Public Works Department

March 5, 1997

**RE: TAPIA LAW OFFICE (J14-D117). GRADING AND DRAINAGE PLAN
SUBMITTAL FOR PRELIMINARY PLAT, FINAL PLAT, AND PRELIMINARY
PLAT APPROVALS. ENGINEER'S STAMP DATED FEBRUARY 25, 1997.**

GRADING AND DRAINAGE PLAN

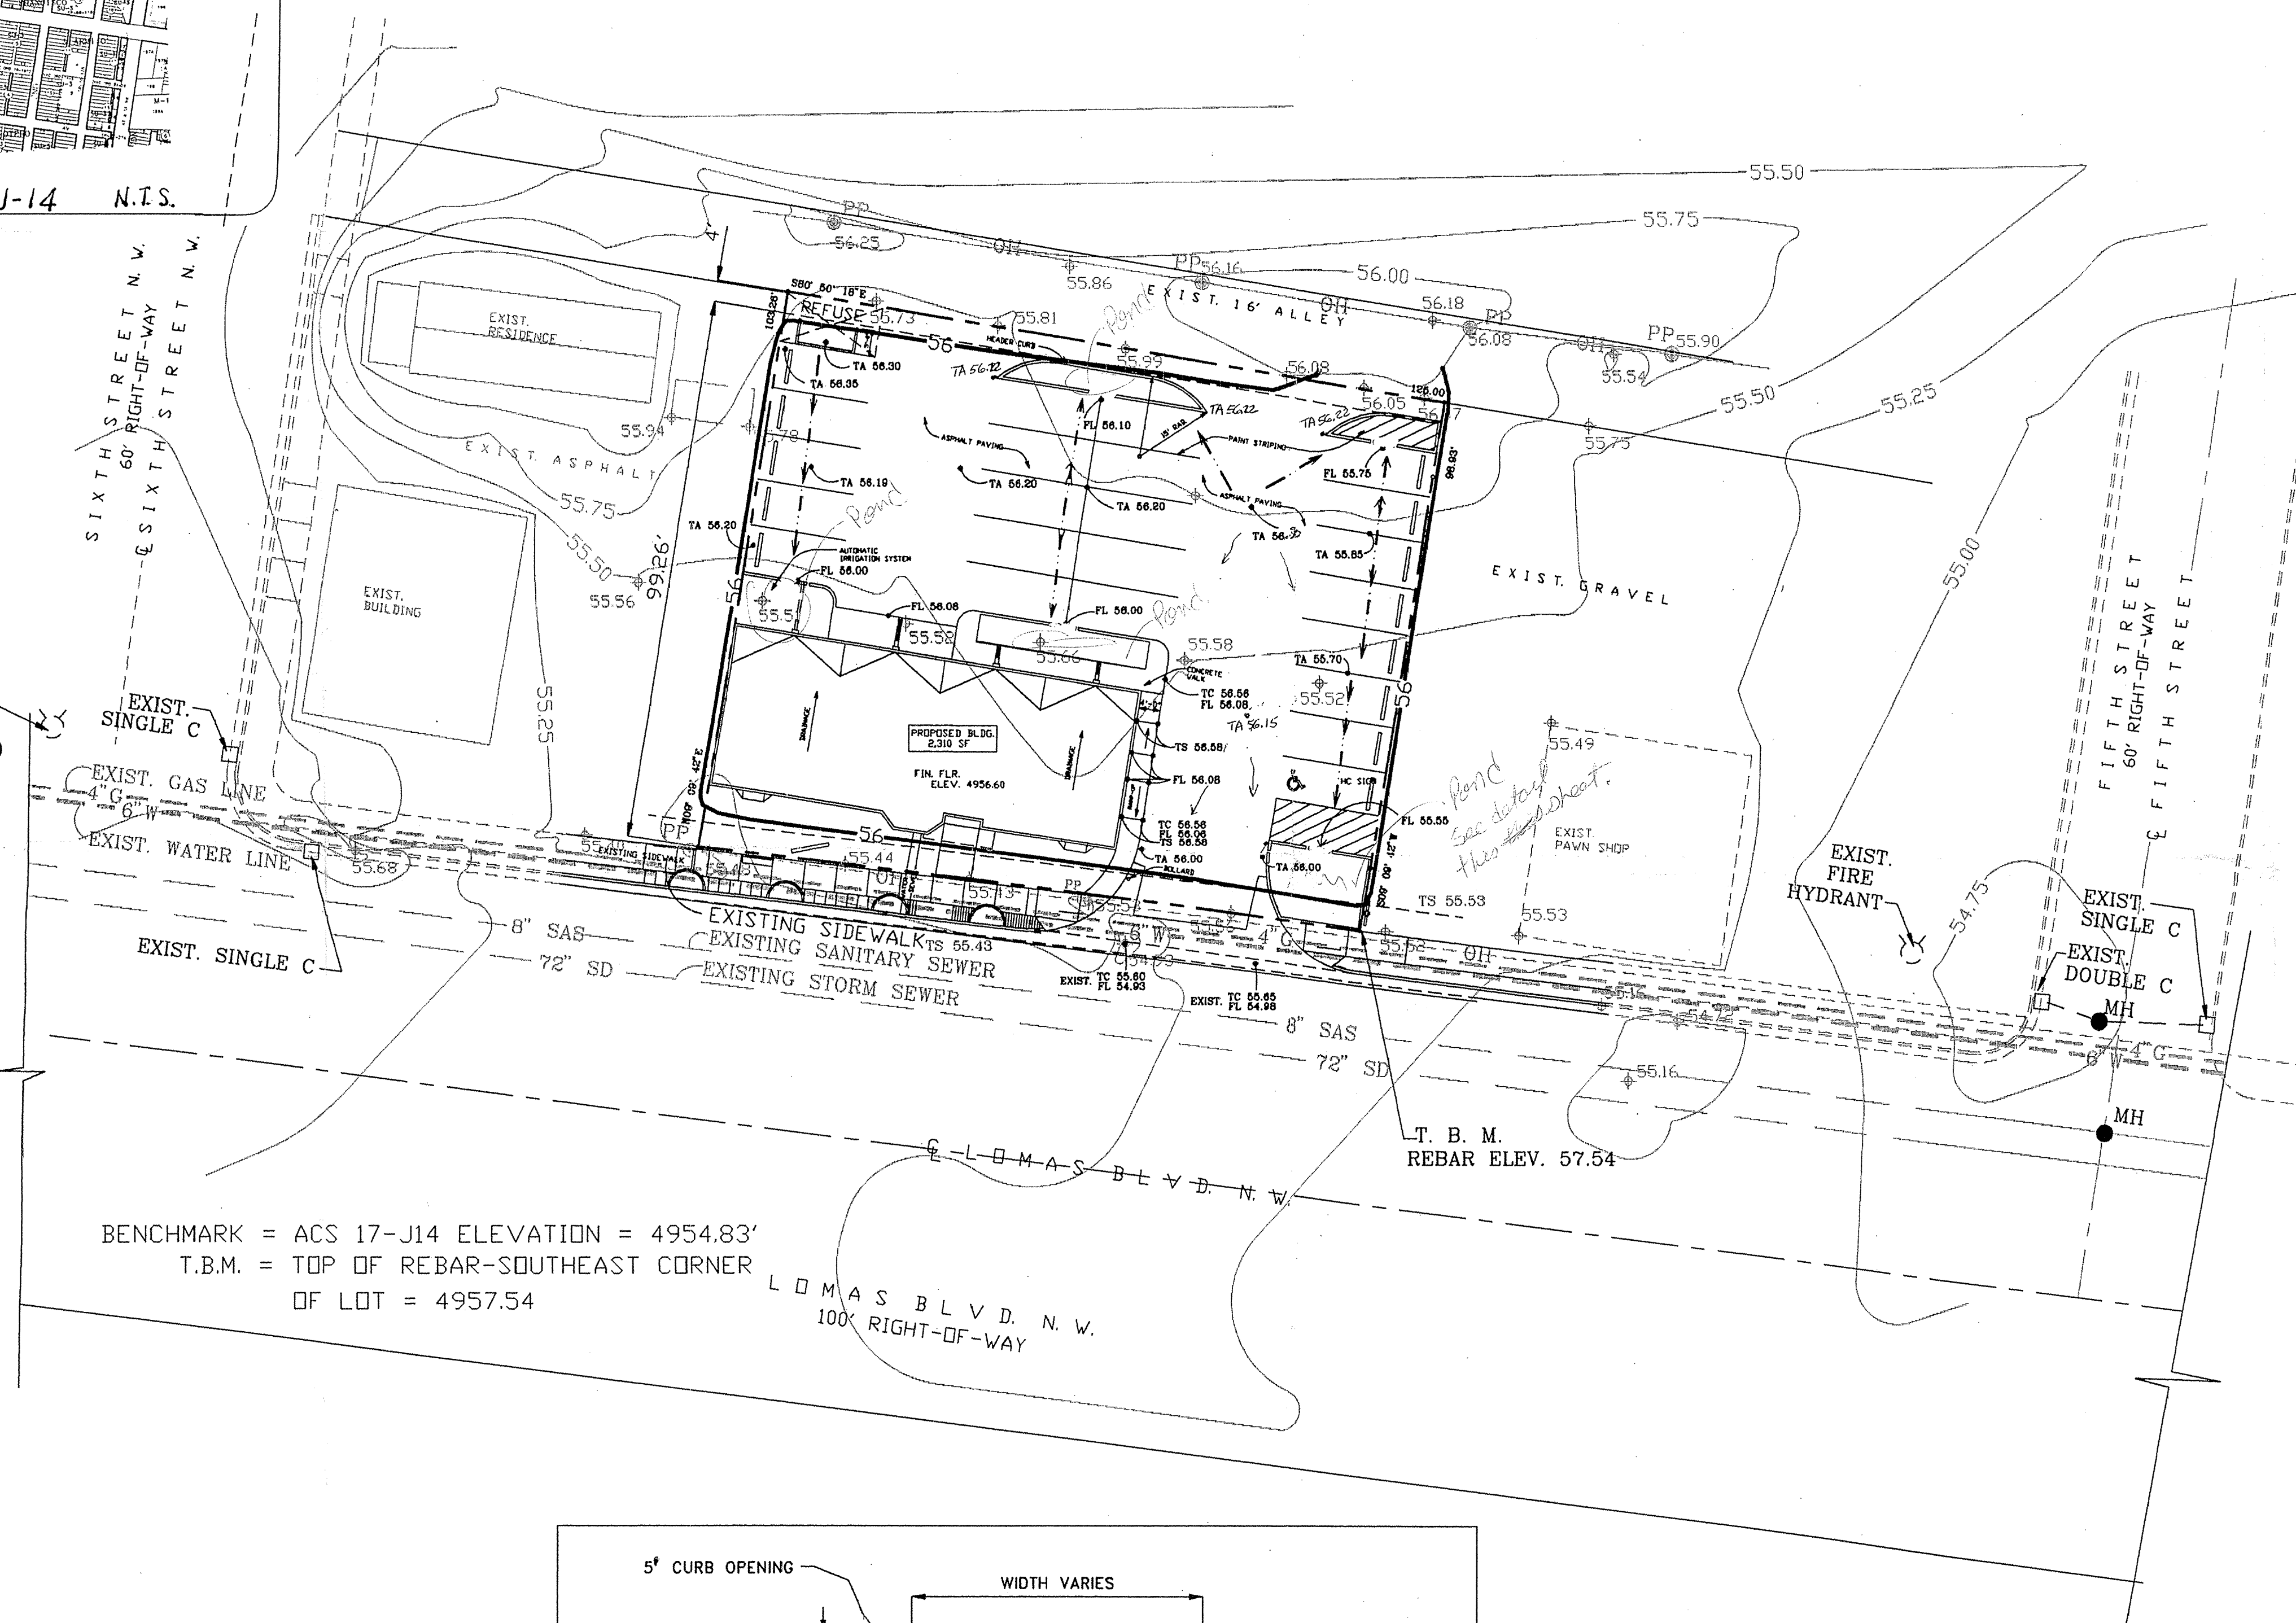
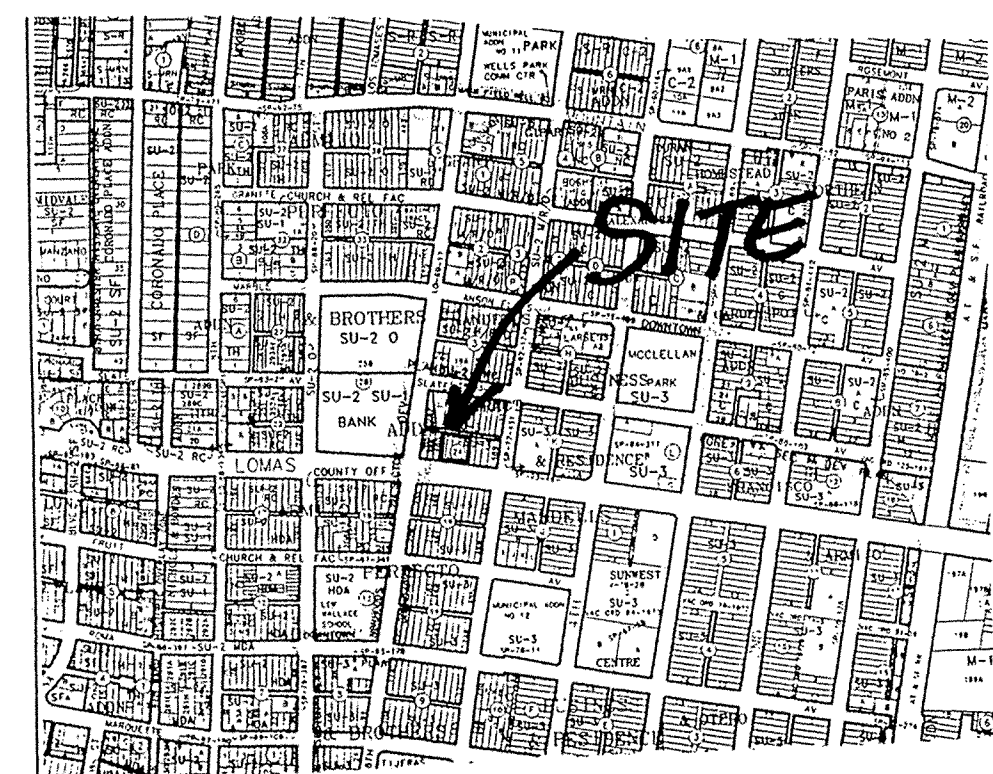
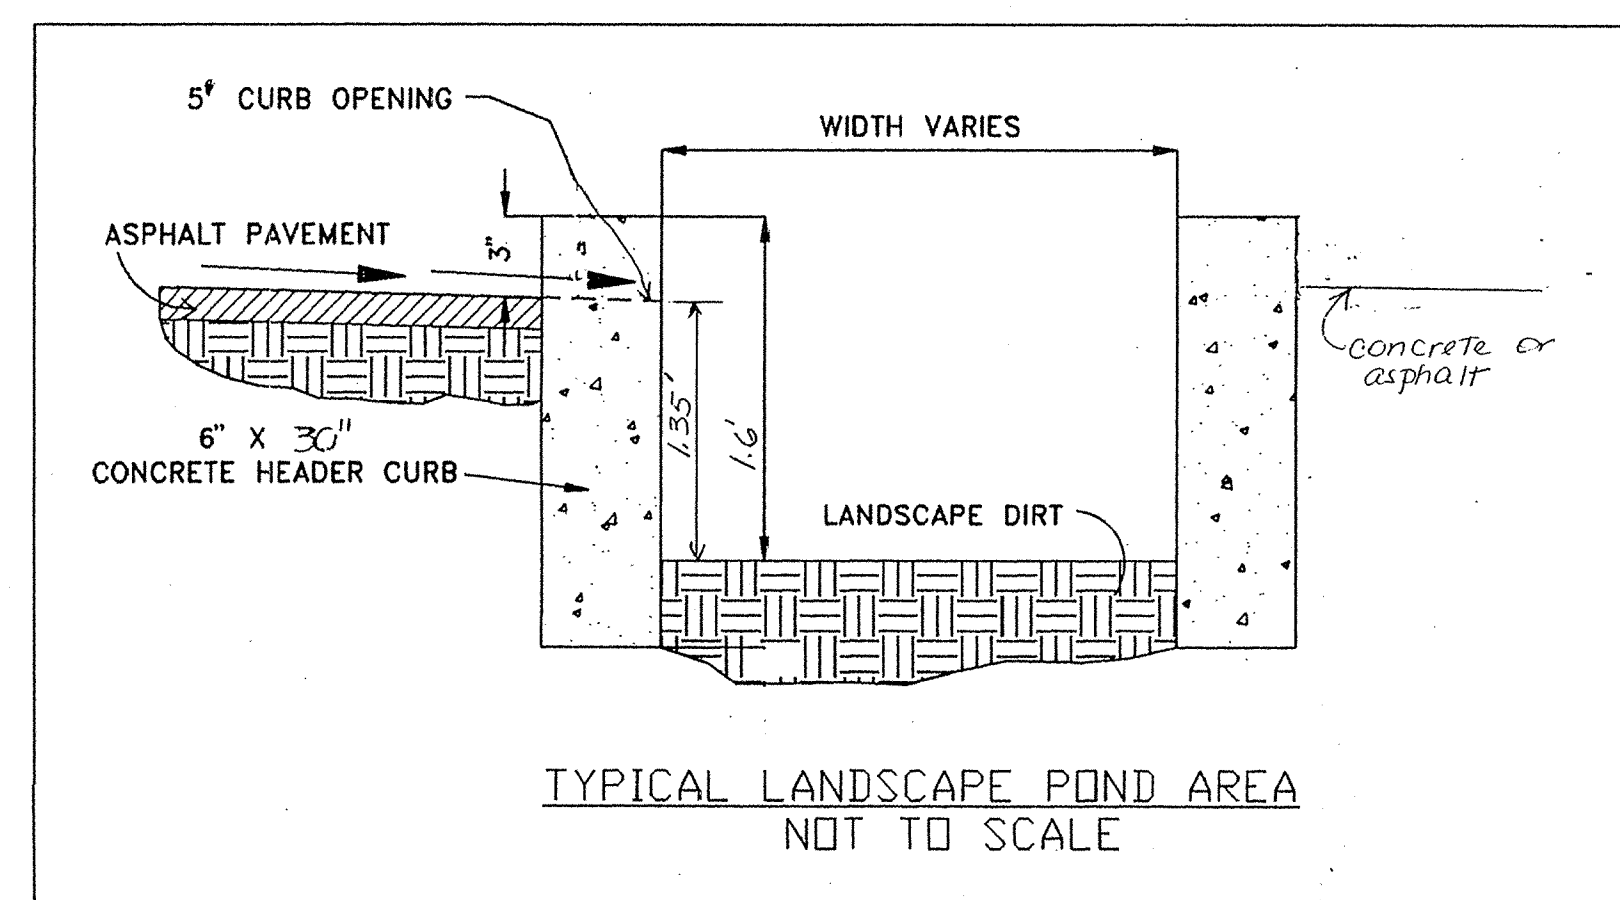
1. Simply stating that you will pond in the landscaped areas
is too vague. Show pond elevations and exact locations.
